MOUNTAIN'S EDGE
PLAN AND PROFILE
EL PASO COUNTY, CO

Road Plan and Profiles_V1.pdf Markup Summary

PCD File No. SF-20-001

## ROADWAY CONSTRUCTION PLANS EL PASO COUNTY, CO

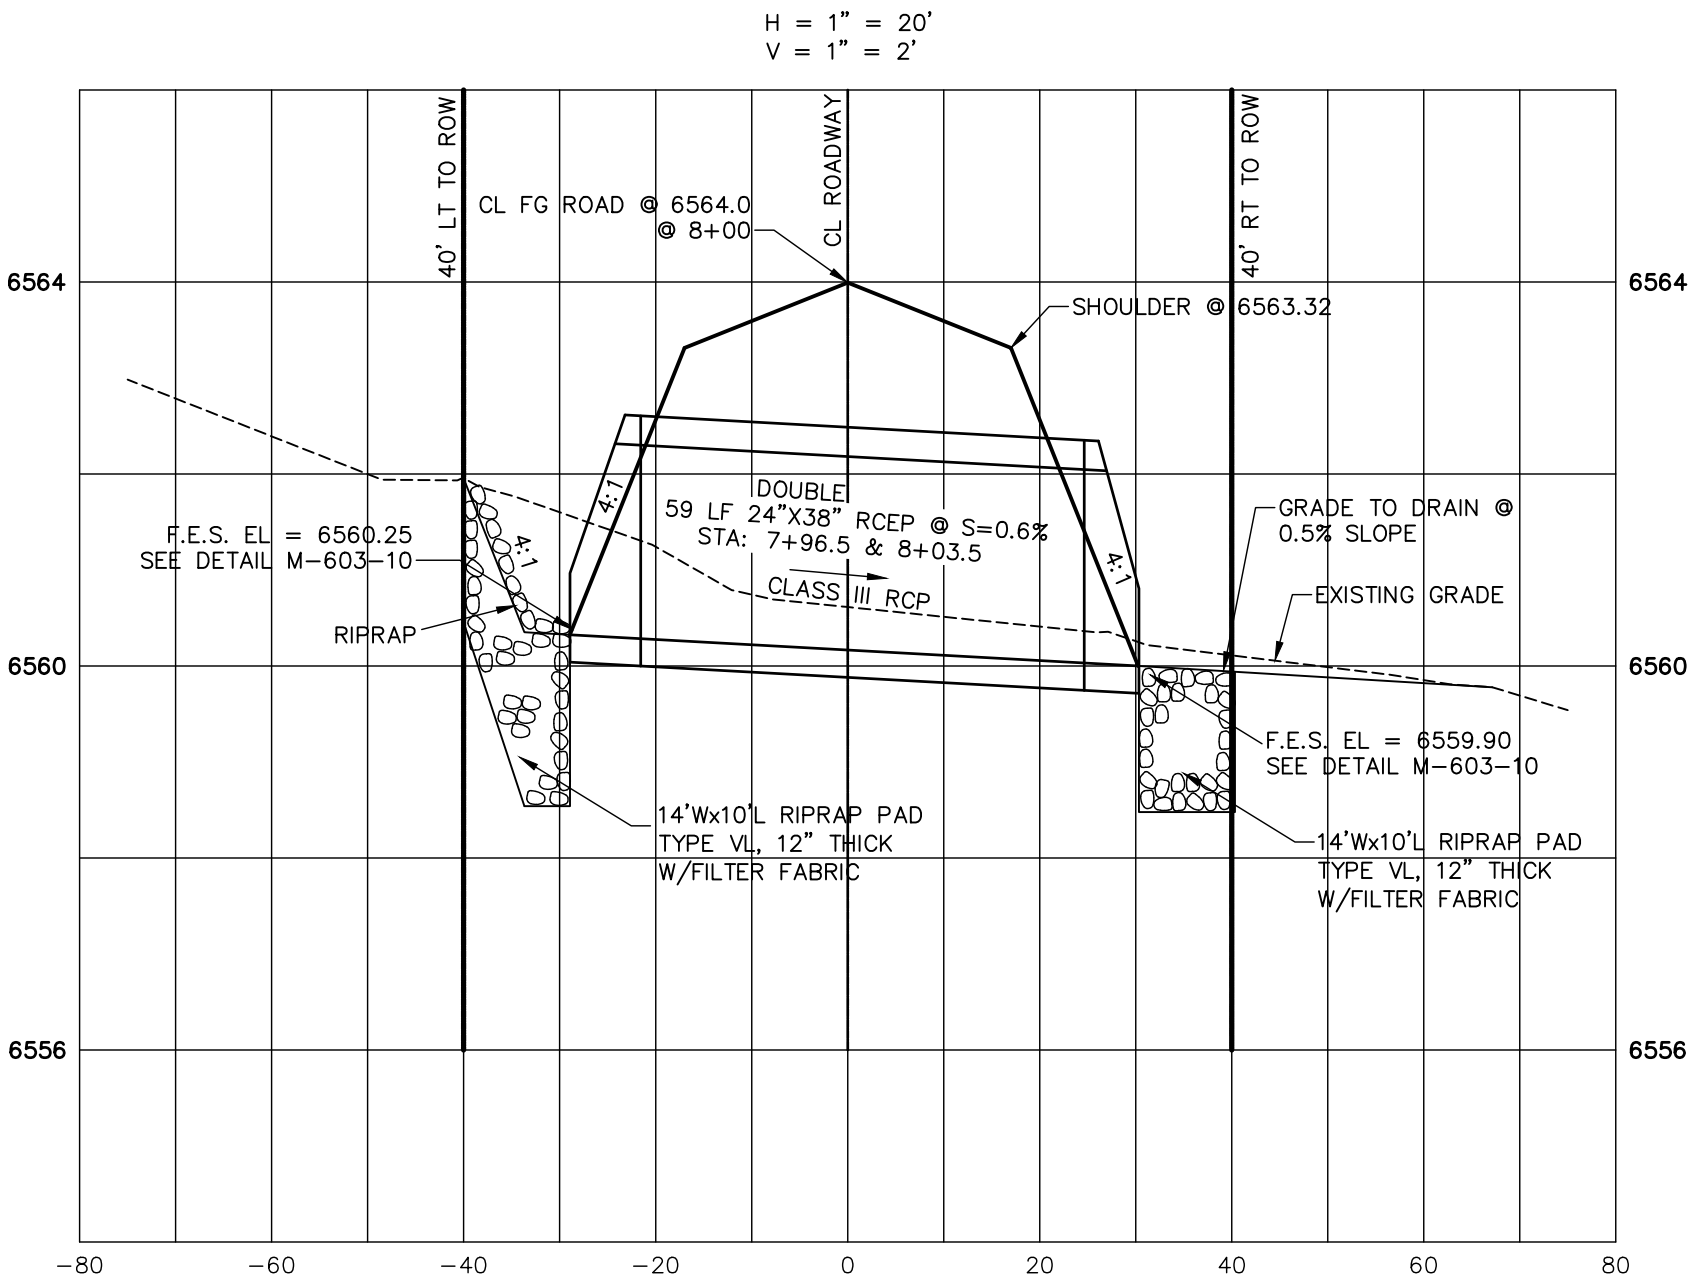
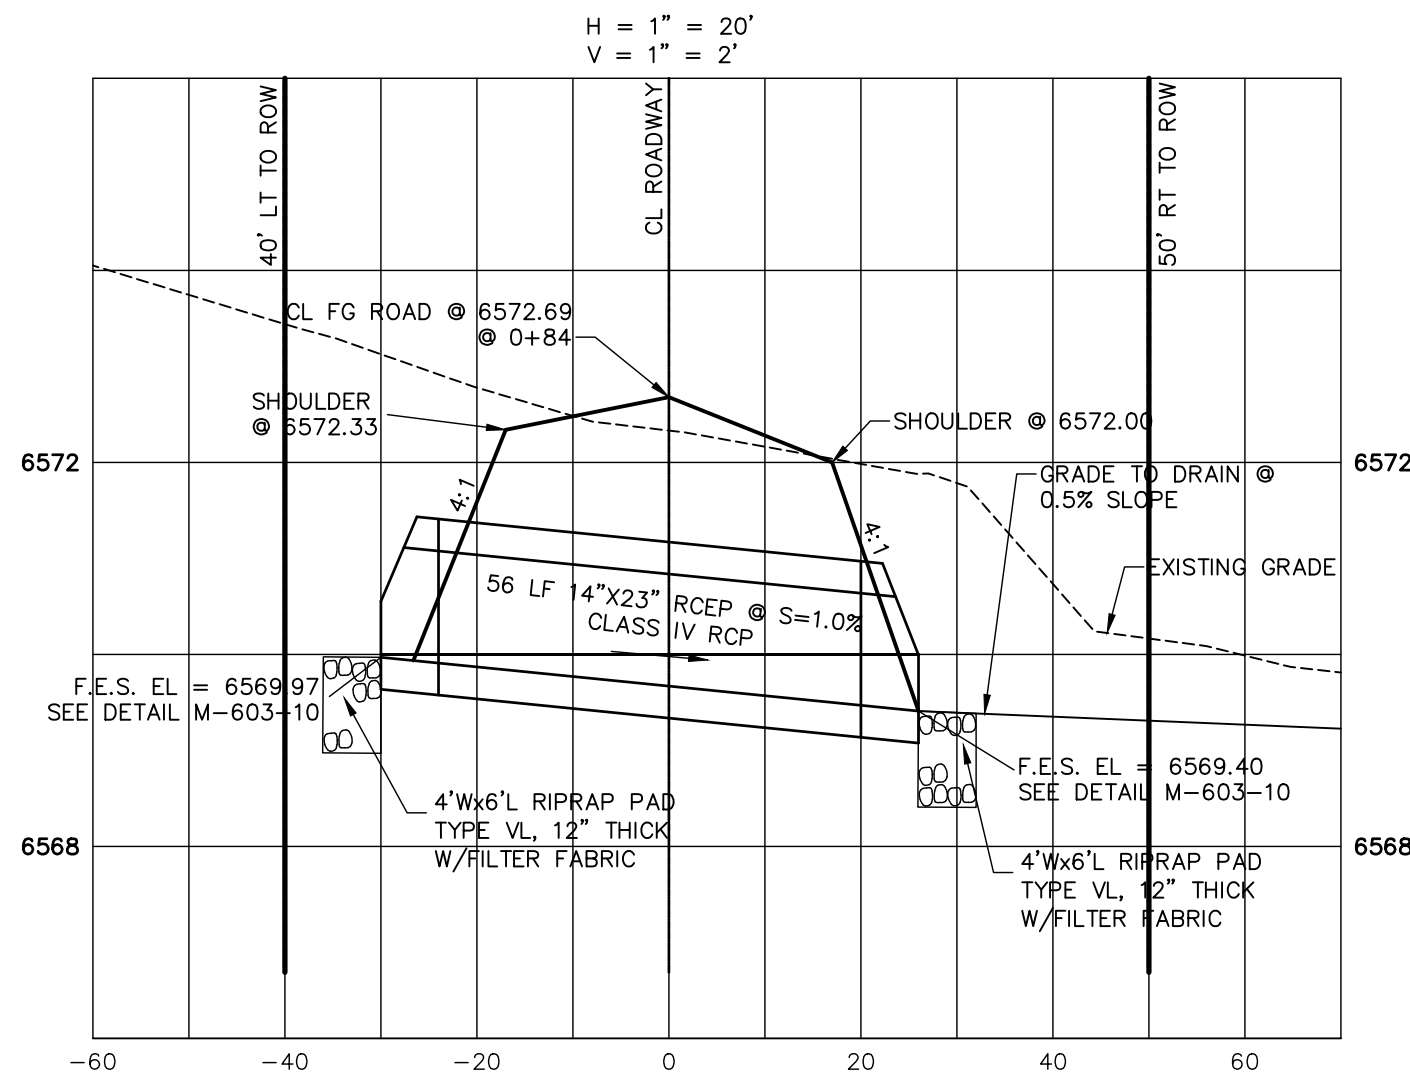
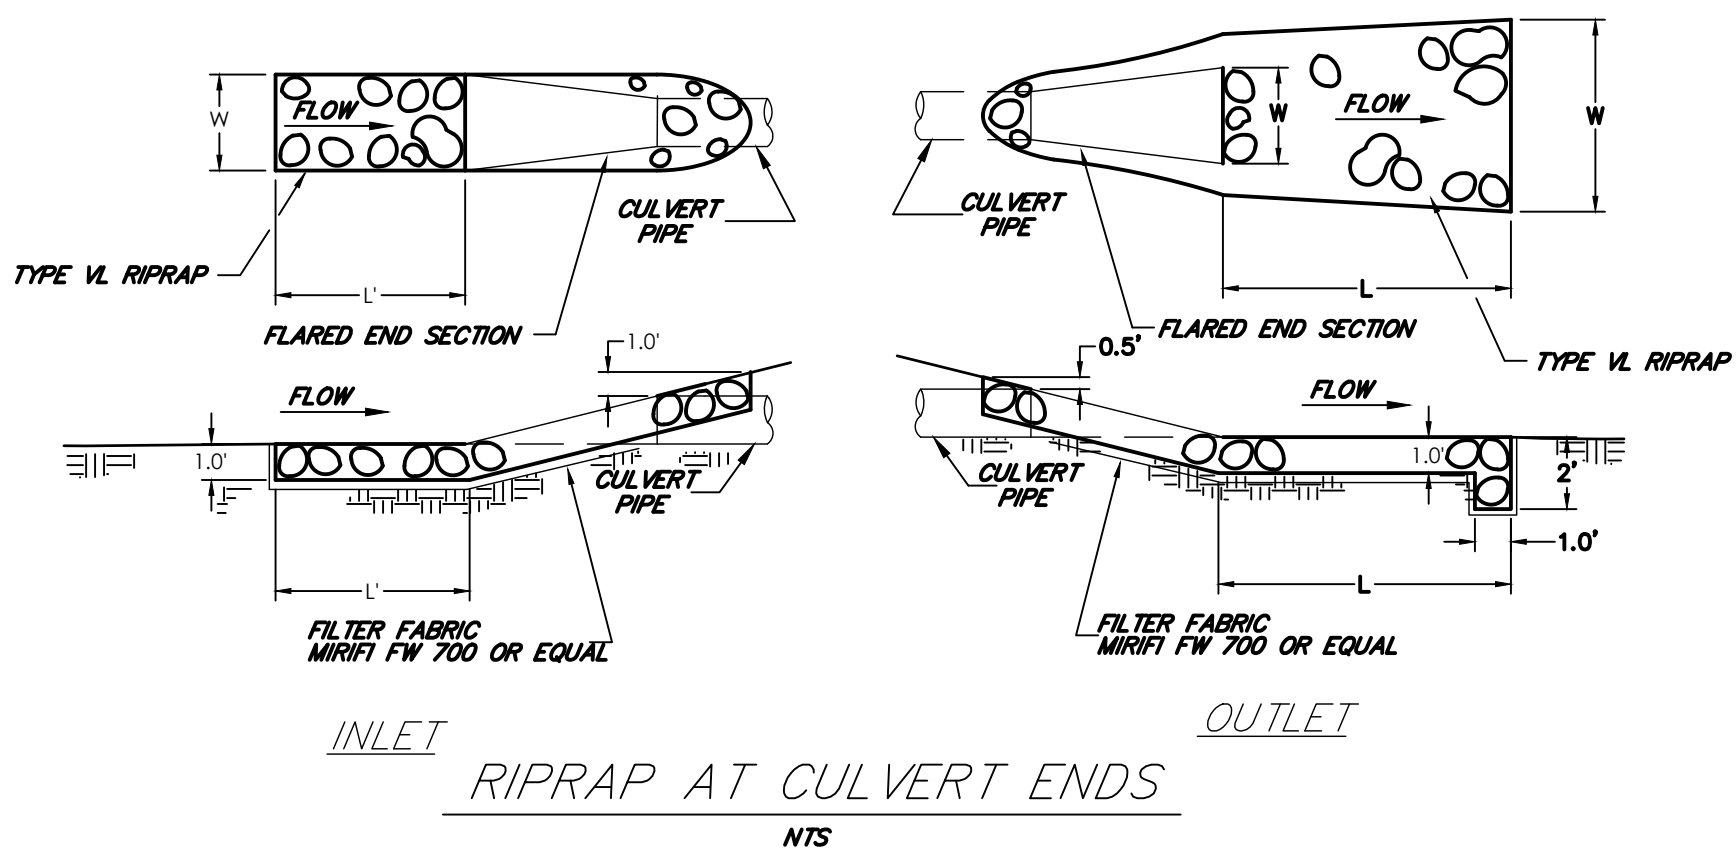
fix viewport to show text.

current criteria is 12' to flowline.

Provide riprap calculation in the drainage report.

Update Label. Plans identify FES not headwall.

Revise to Roadway Construction Plans

Identify the horizontal separation between the two pipes.

FES doesn't seem to be the appropriate end treatment for multiple pipes. Revise to headwall and wingwall. Provide construction level details. Contact the review engineer to discuss.

Install cutoff walls at the FES

Add the EPC Signing and striping notes

Project No.: 08019
Sheet: 3 of 3

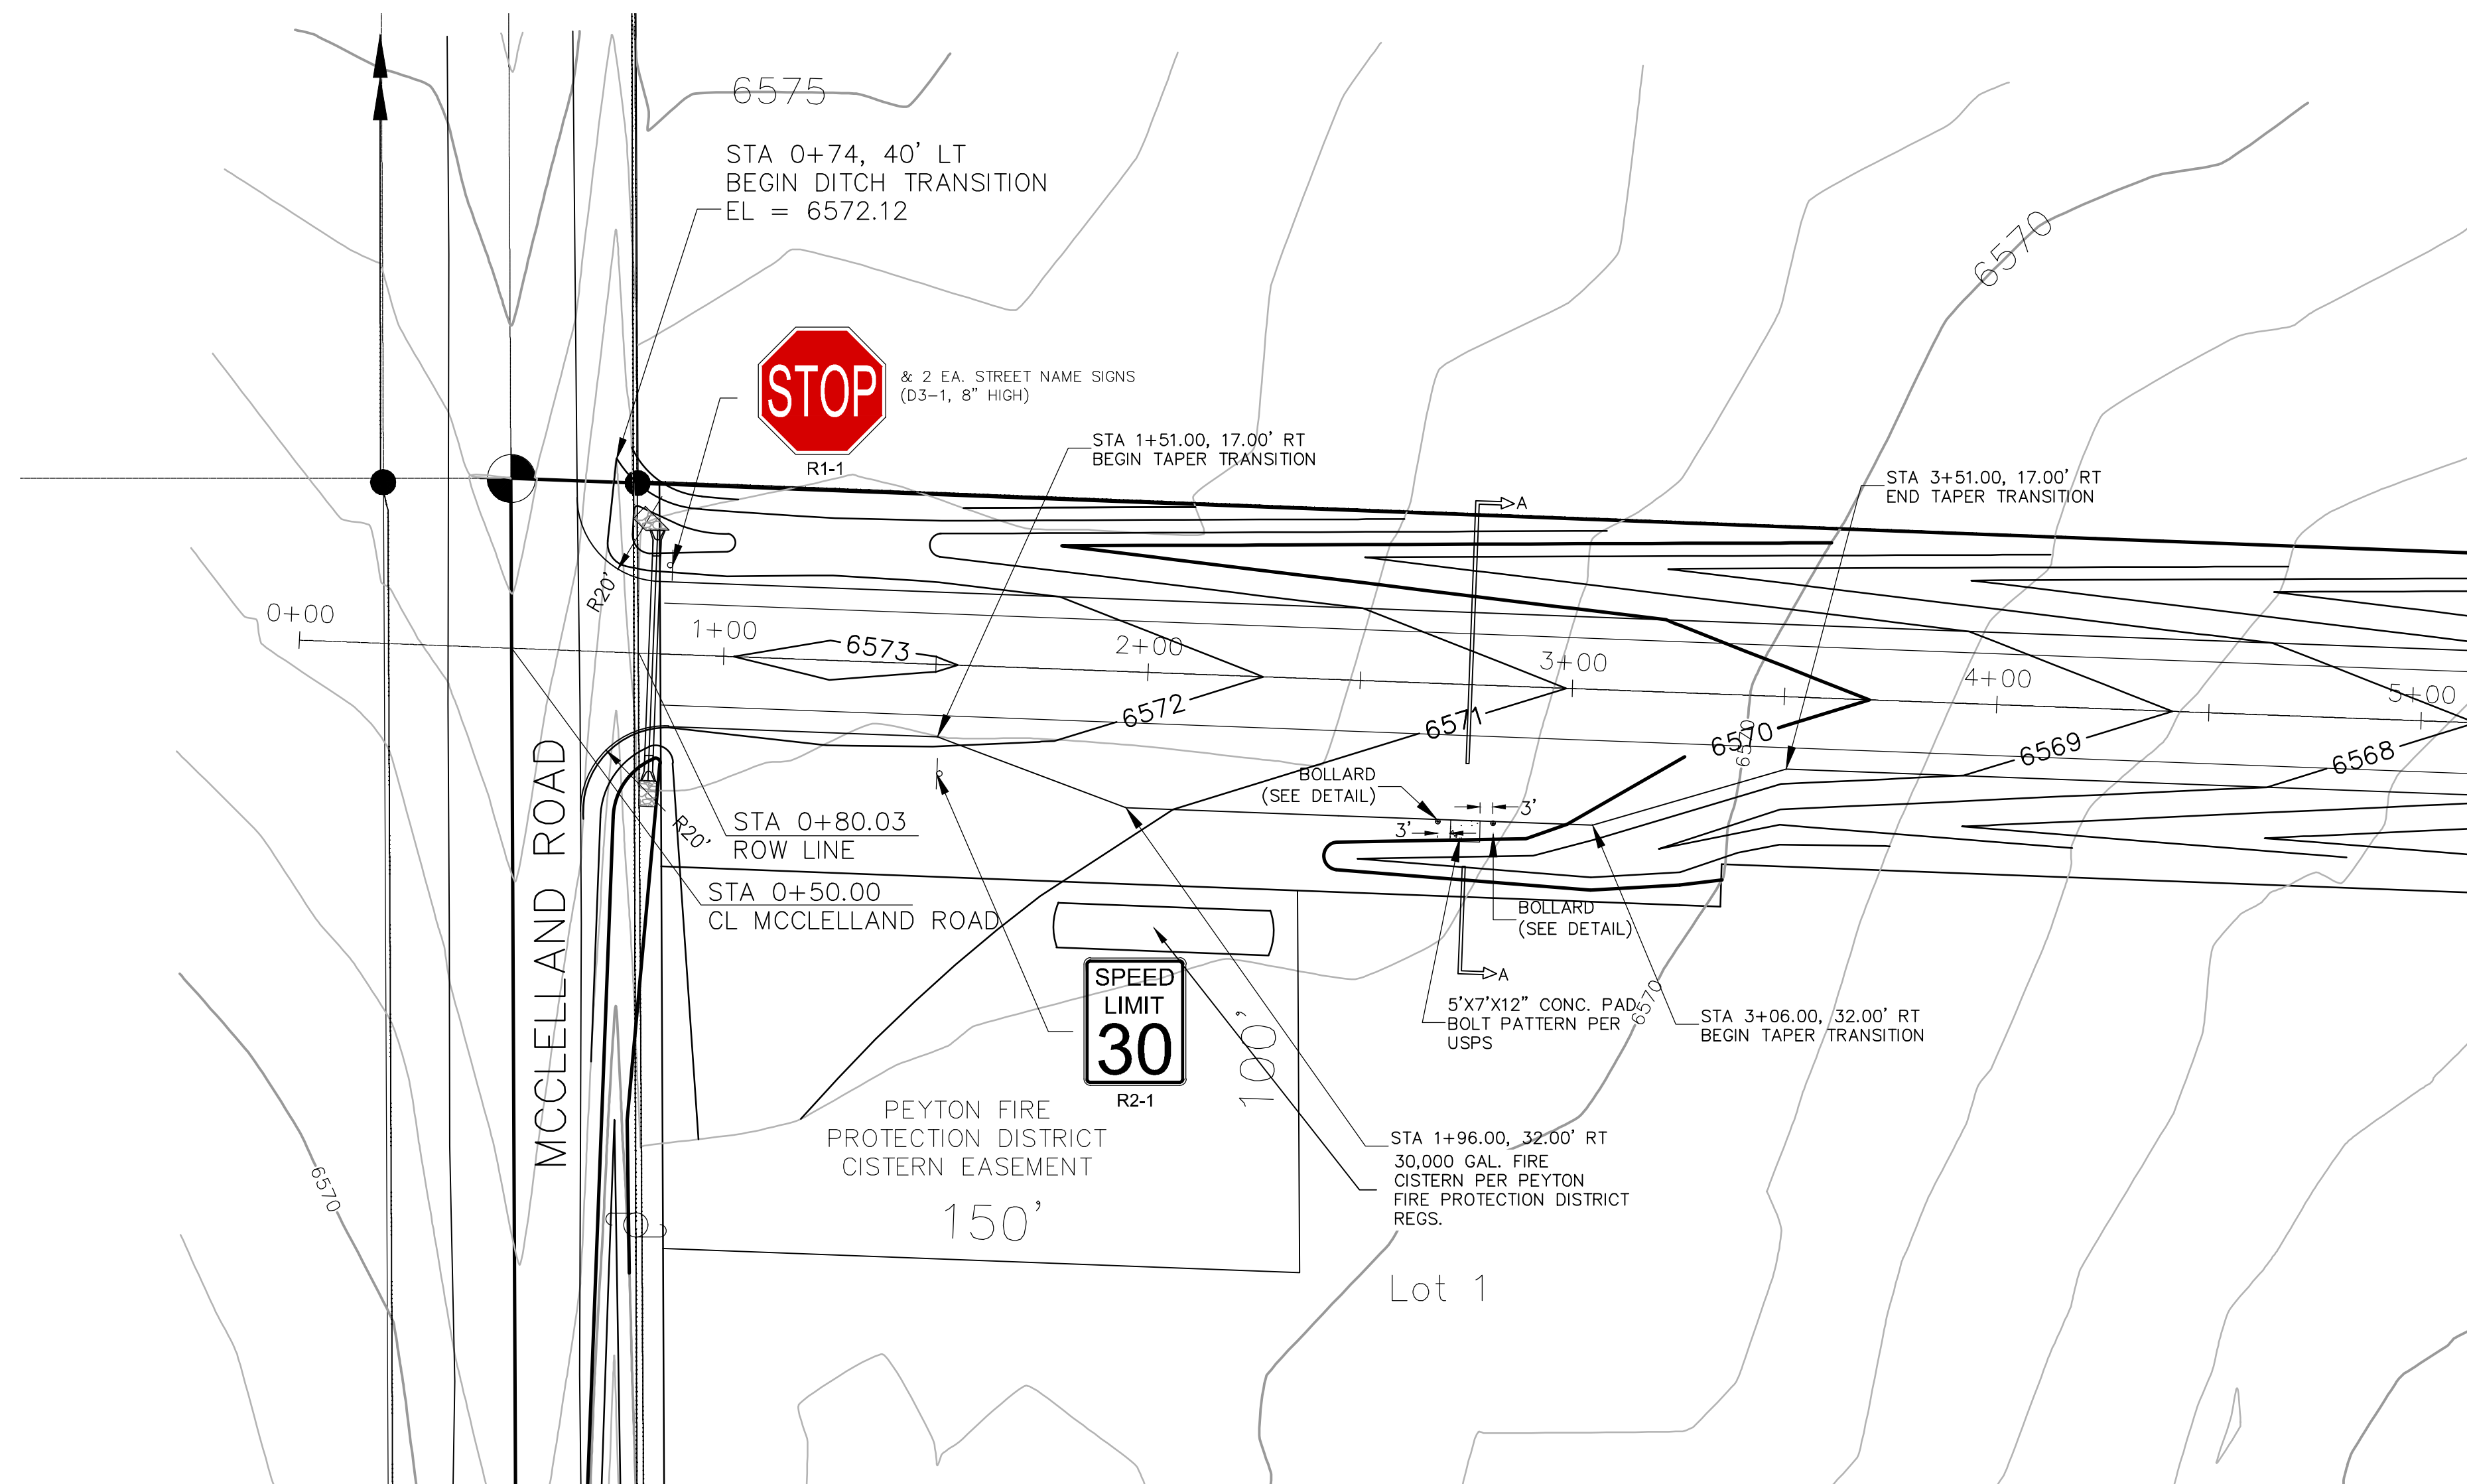
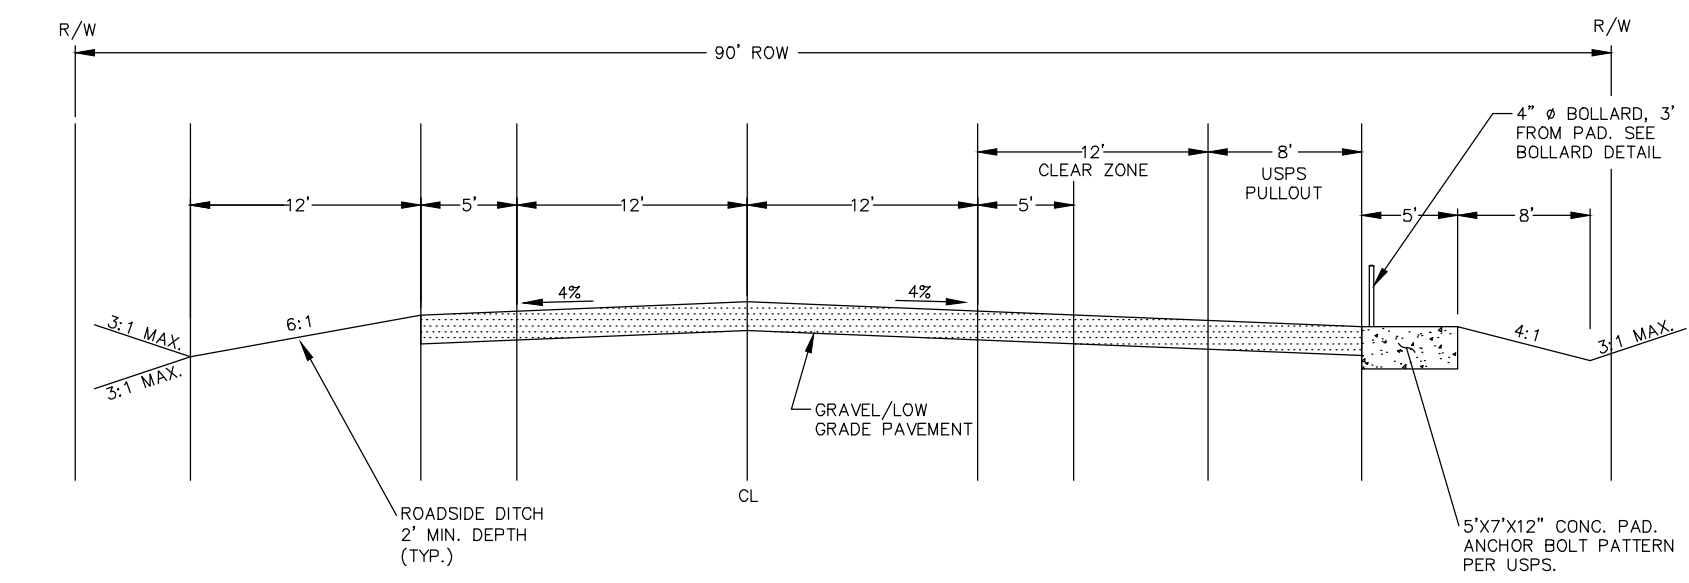
Mailbox pad pull-off area does not meet criteria.
See ECM 4.4.5.E.
See figure 4-2 above. The pullout must be outside the roadway clear zone and a minimum 8' wide. Additional ROW and a license agreement is required.

Per table 2-5 clear zone for a rural gravel road is 12' from the travel lane.
